Date: 2022.06.12

RE: Commentary Response per Permit No. 2112-250

This letter is in regards to your INITIAL review of the proposed single-family residence. Please see below for a response to your commentary in *italics* and our responses in **bold**. Thank you.

**UPPER FLOOR & LOWER ROOF FRAMING PLAN**  
SCALE: 1/4" = 1'-0"

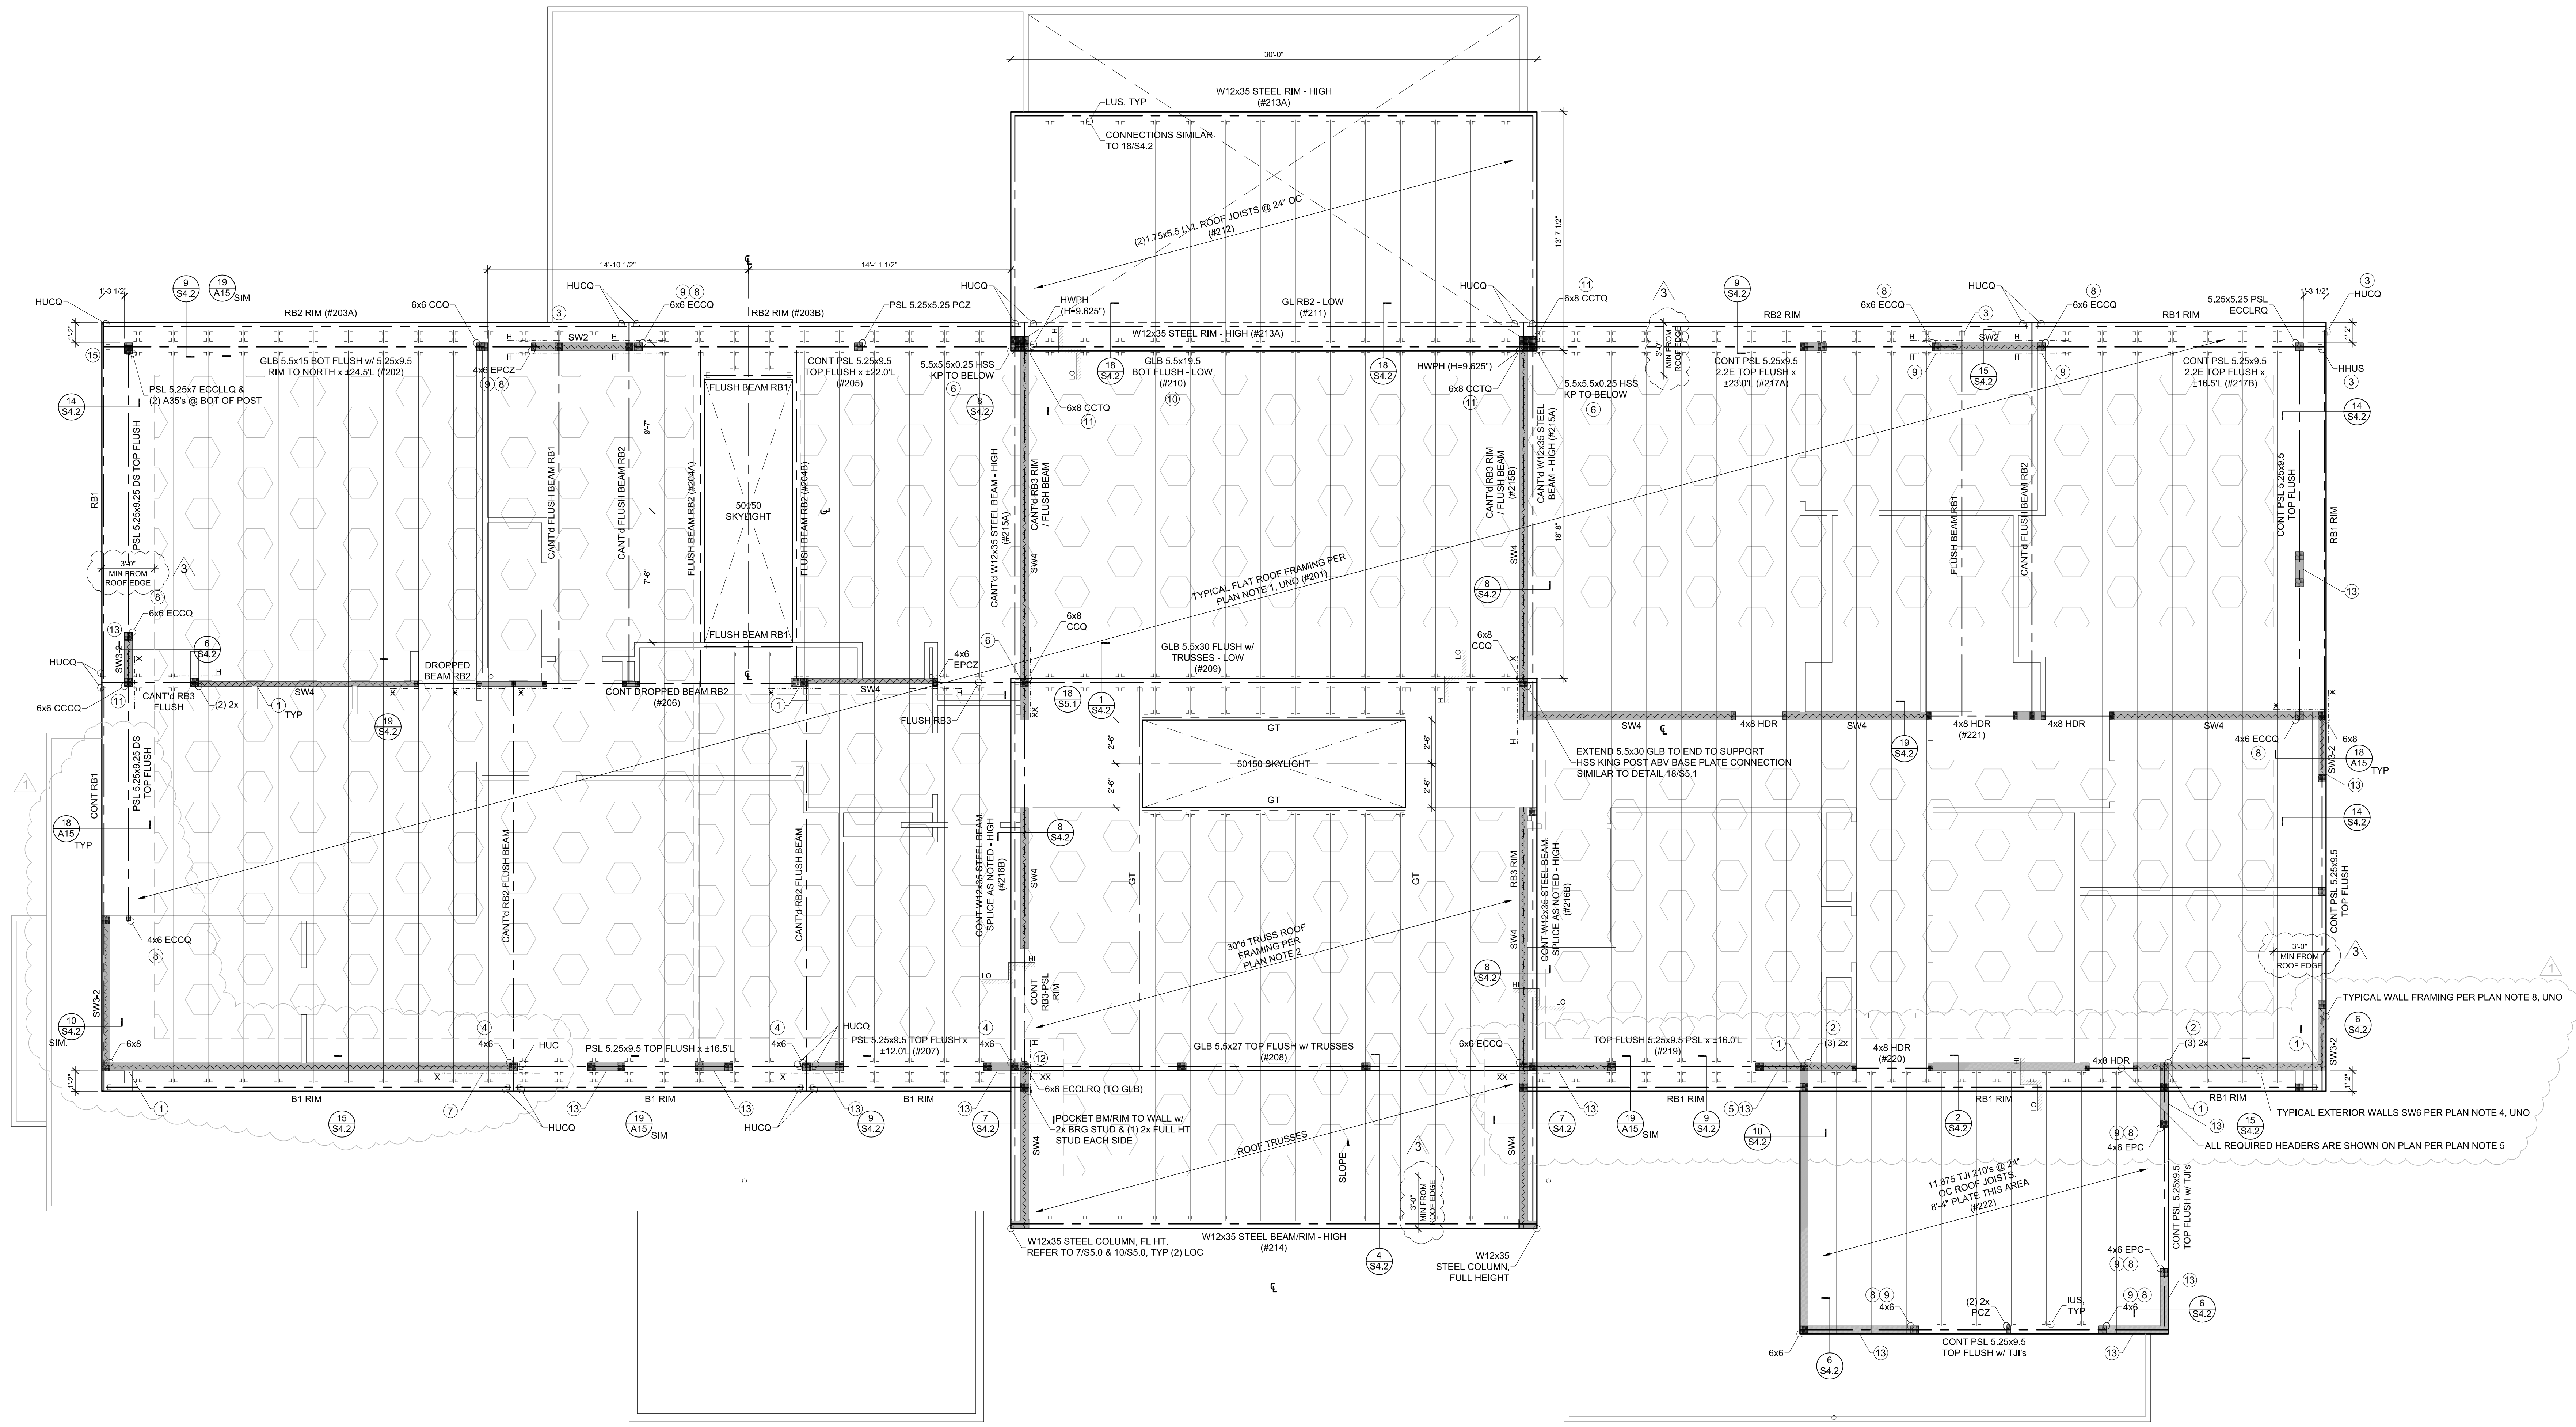
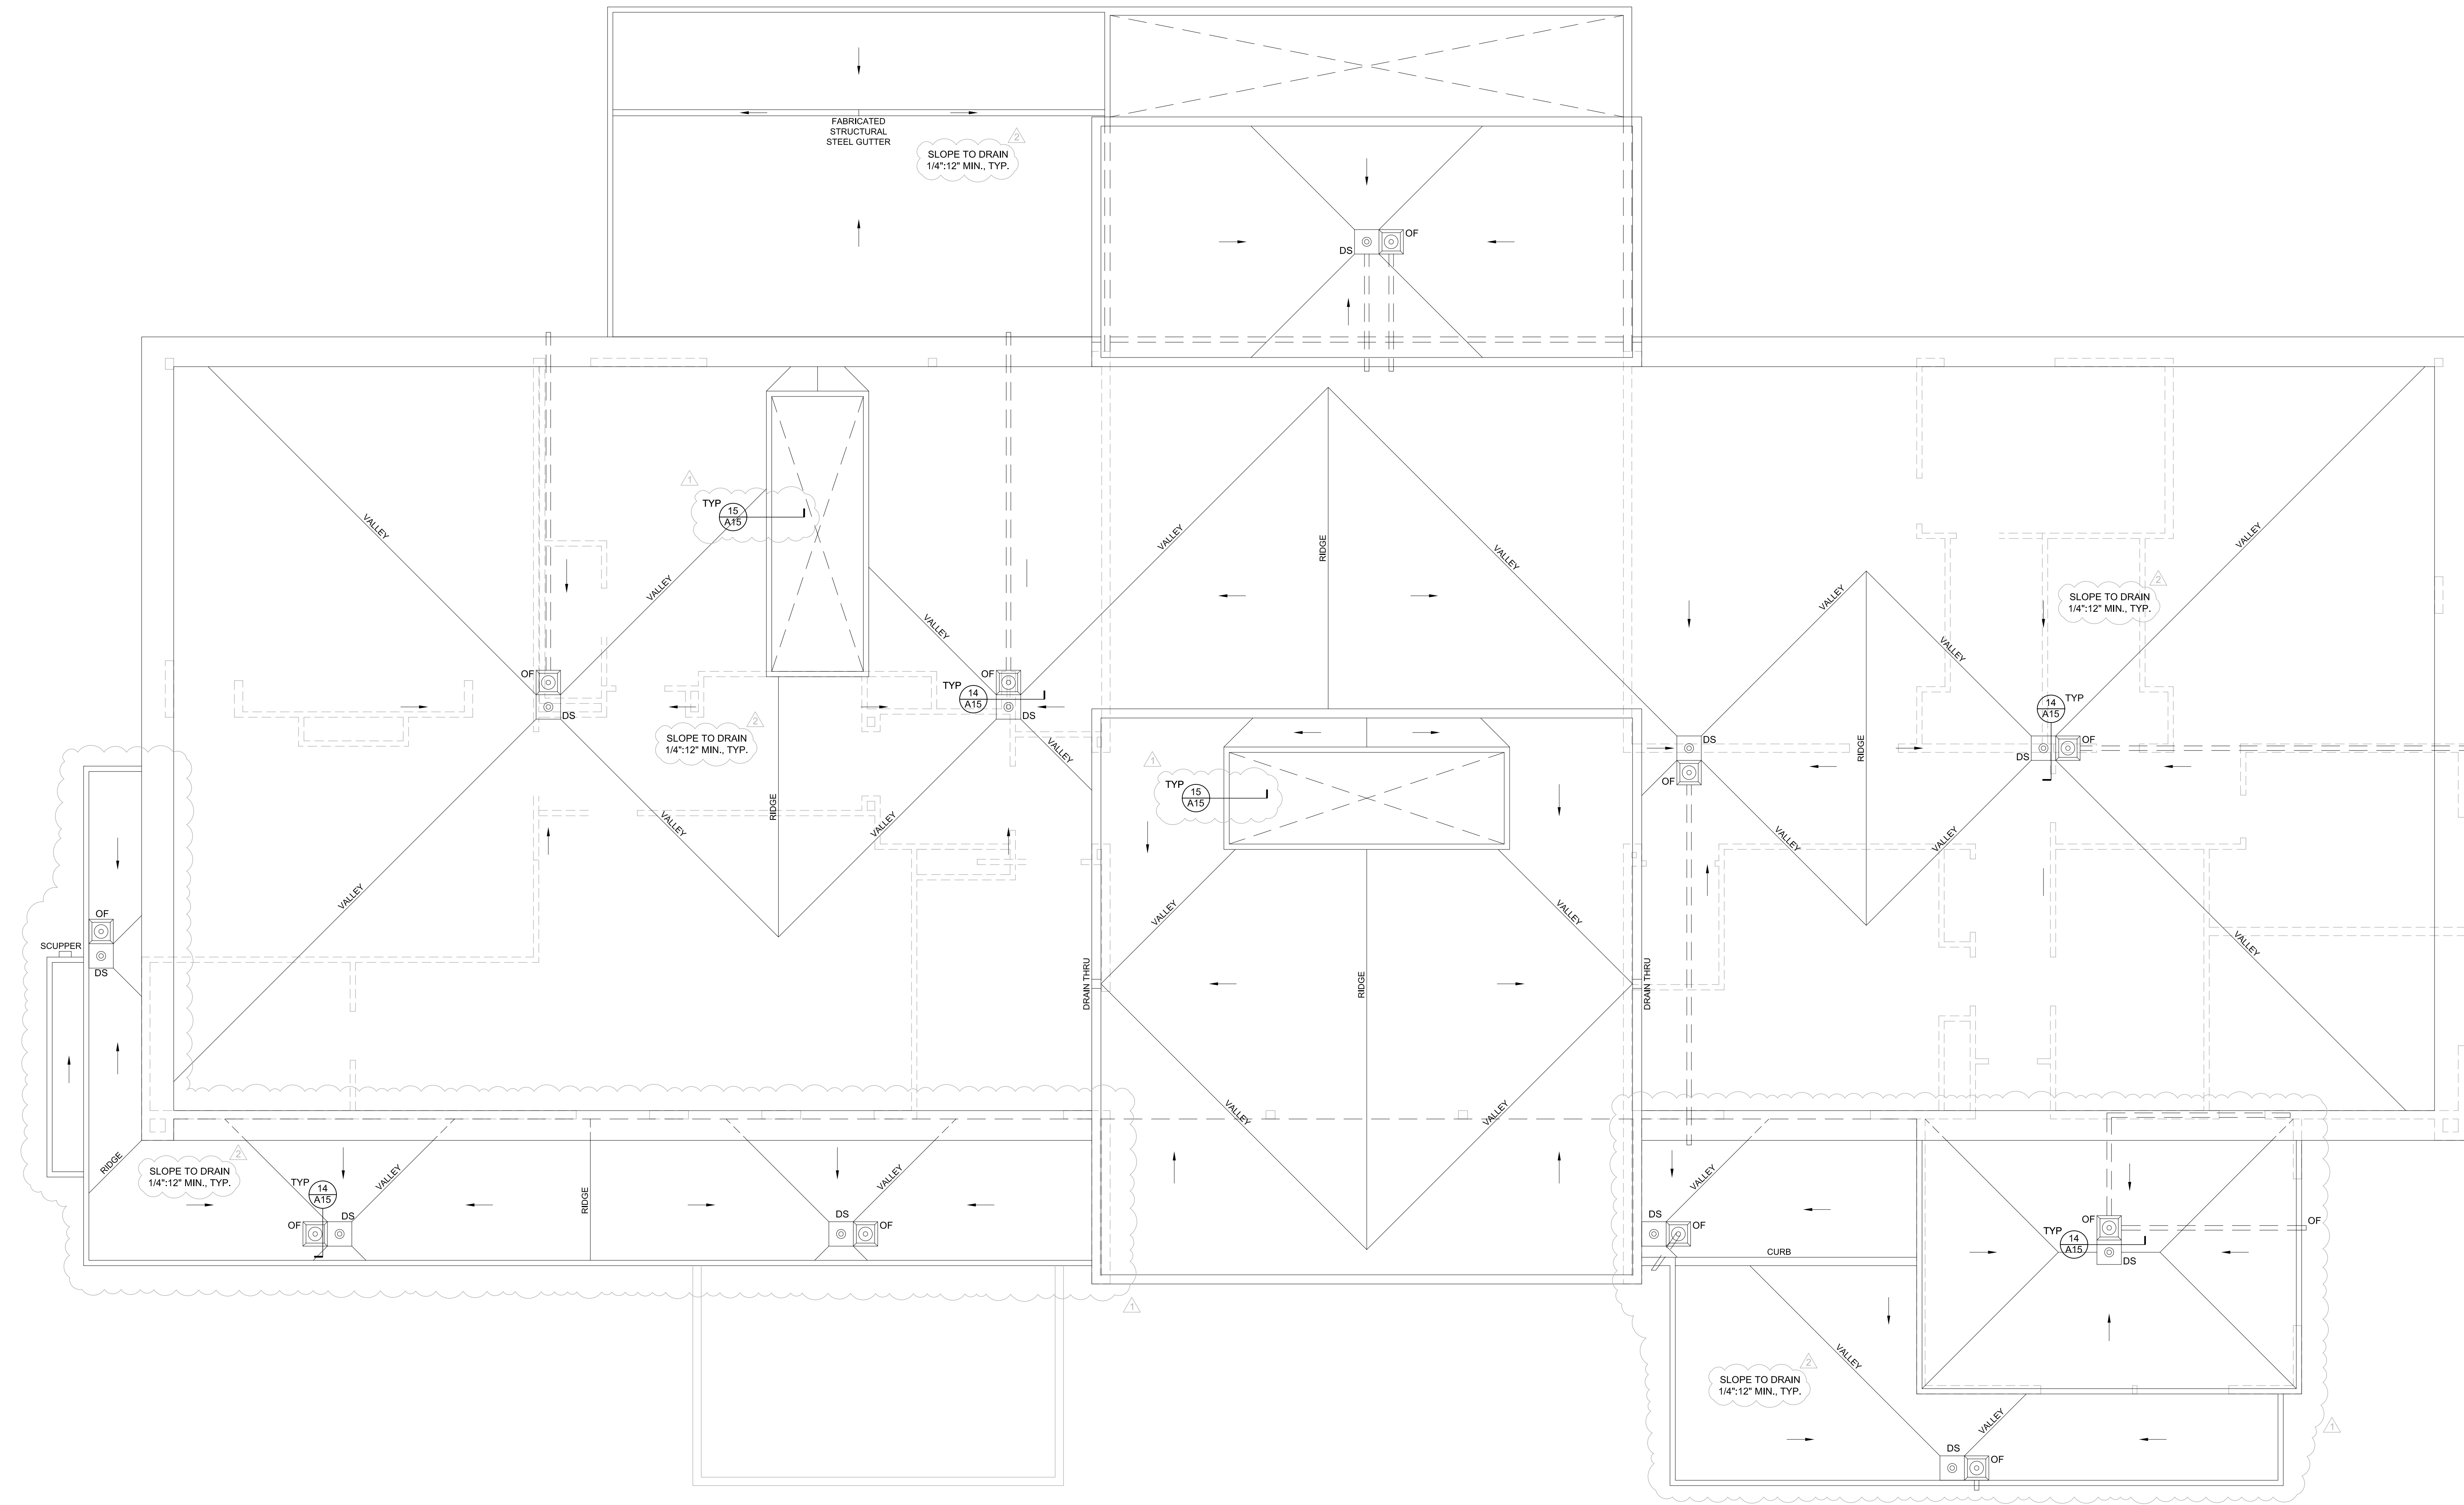
- a. **Typo revised to reflect correct Energy Credit Option.**
2. *Energy Credit Option 6.1 has been selected per WSEC Table R406.3 for the Renewable Electric Energy Option. You must provide calculations providing documentation for the sizing of the system, weight of the panels, and roof layout noting solar access on the plans. Roof access, pathways, and setback requirements must be provided per IRC R324.6 for rooftop-mounted photovoltaic systems.*

- a. **Information regarding the solar panel system has been provided. Extent of area of panels indicated on sheet A8 for reference on architectural/structural plans.**

**A10**

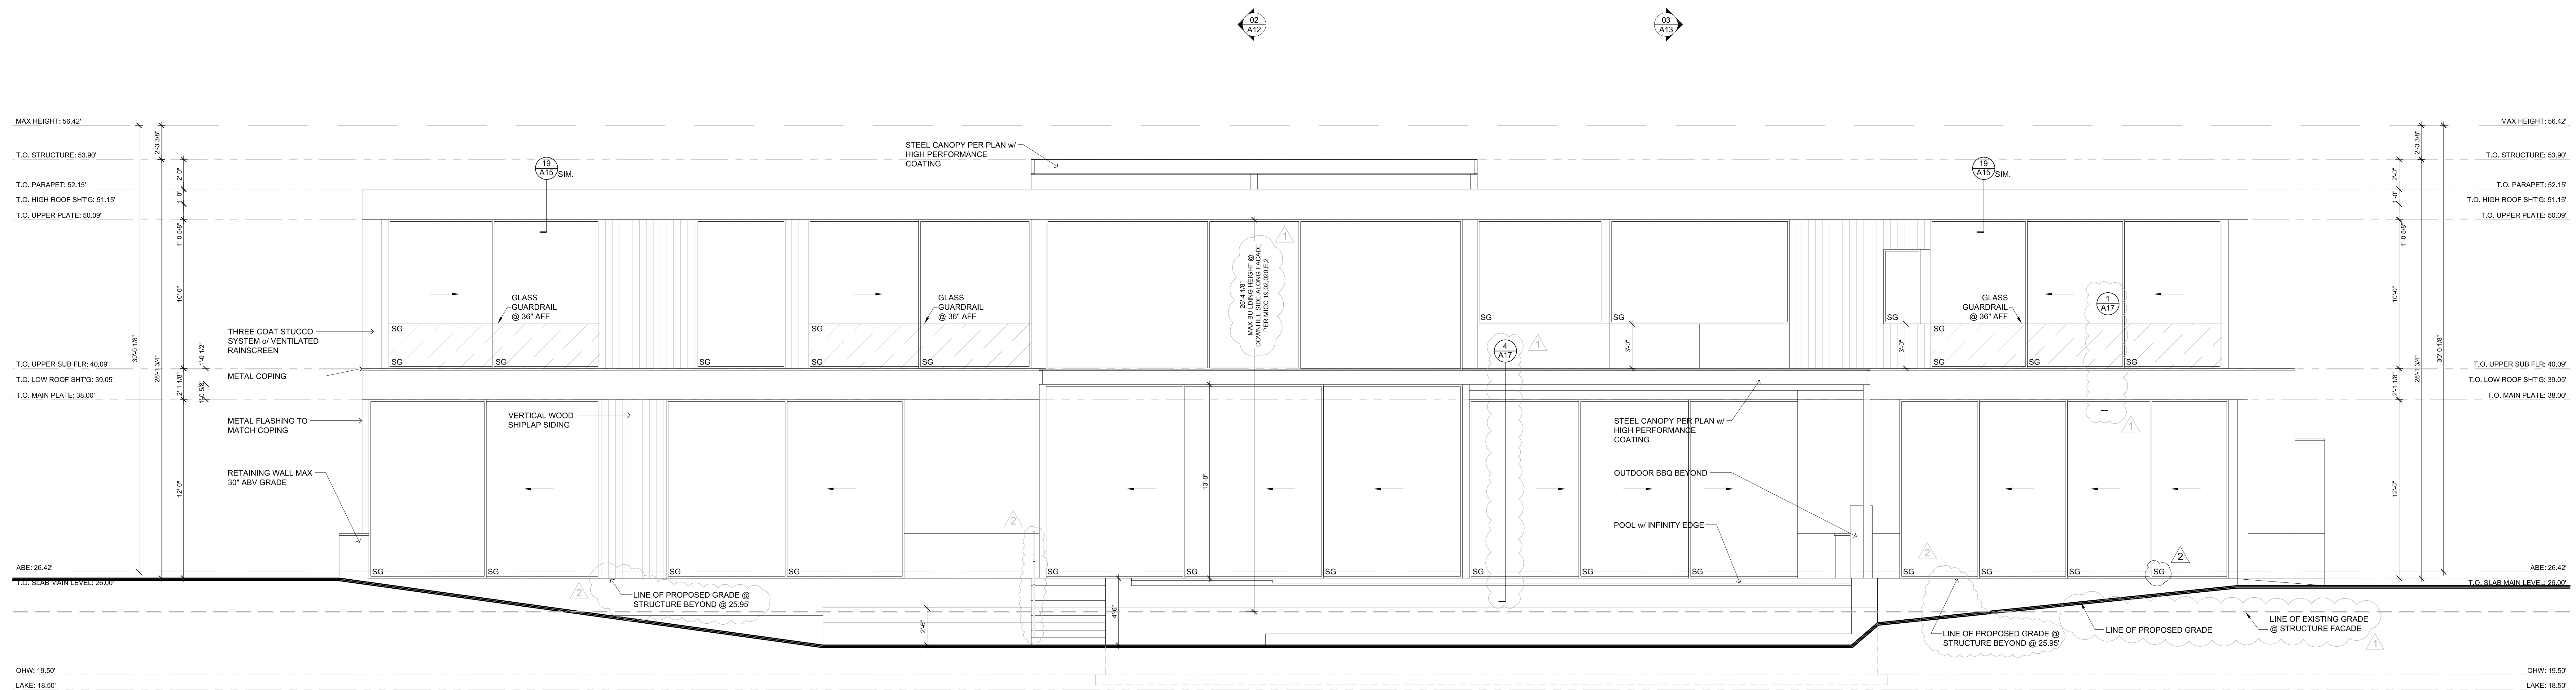
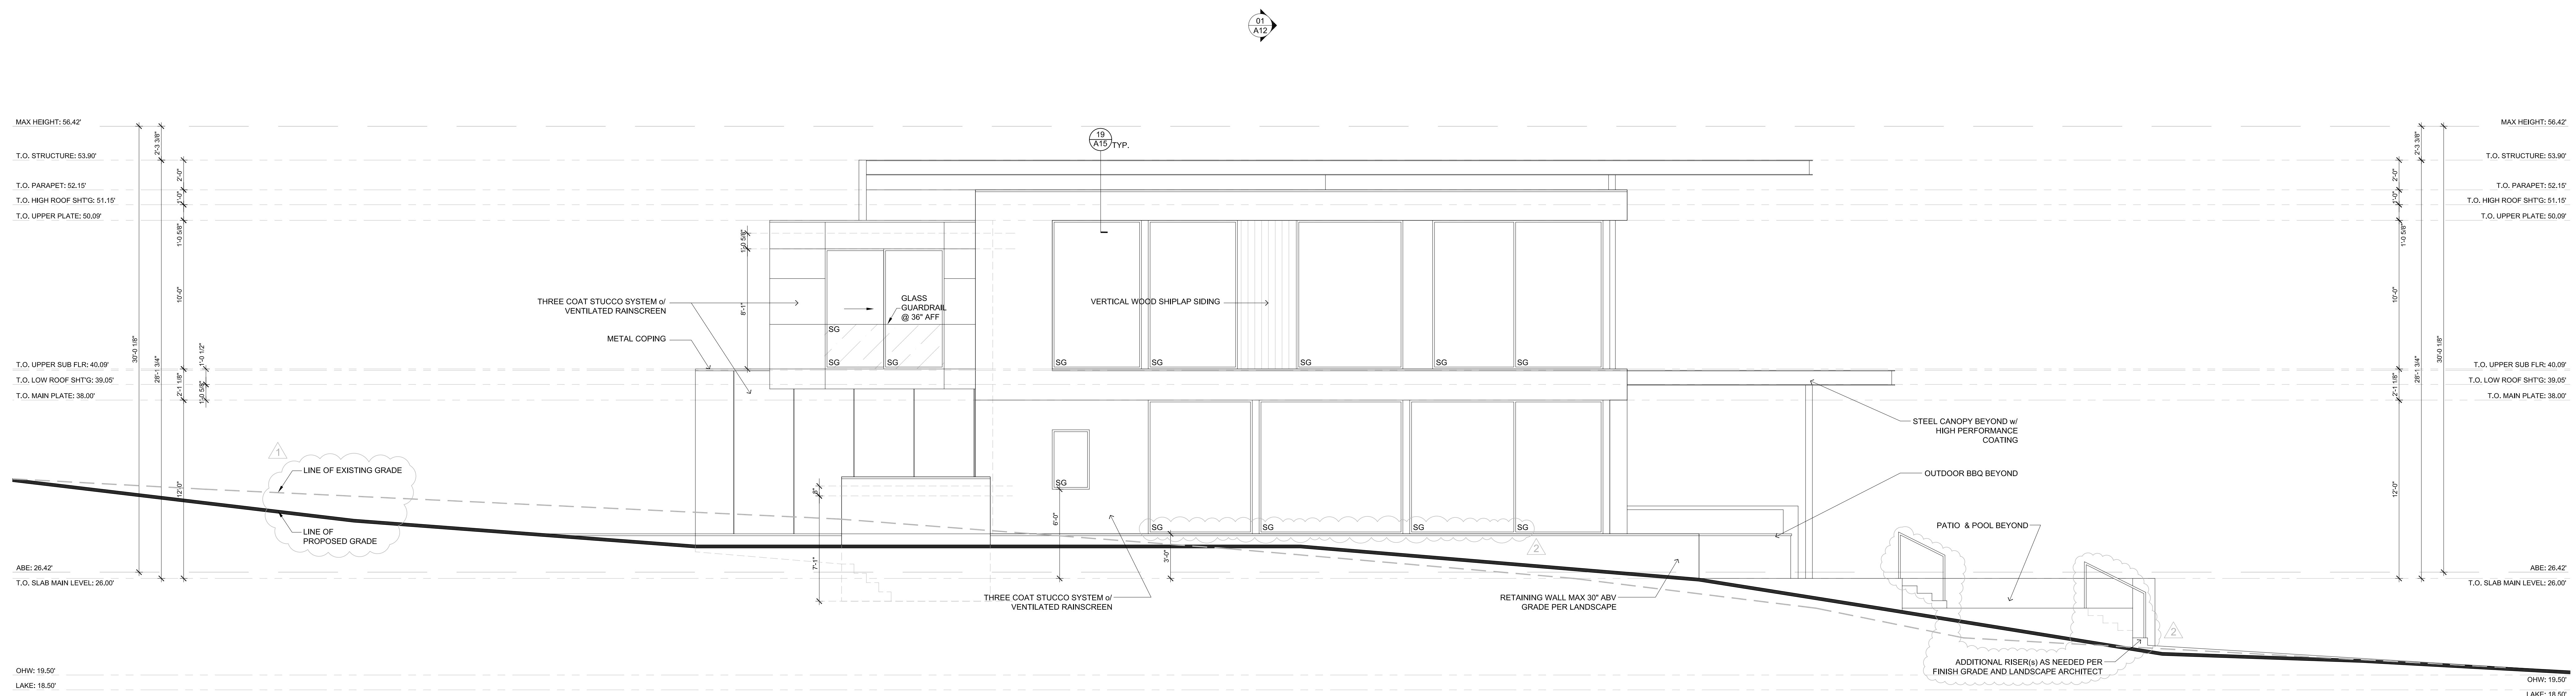
- i. **Sheet A1 revised to A0 – Cover Sheet.**
  - c. *Complete elevations clarifying finishes at all locations, detail guards, and complete all other exterior elements.*

- i. **Additional annotation provided further defining exterior finishes. Guardrail details provided, see sheet A17. See sheets A10, A11, & A17 for further definition and detailing of exterior elements.**
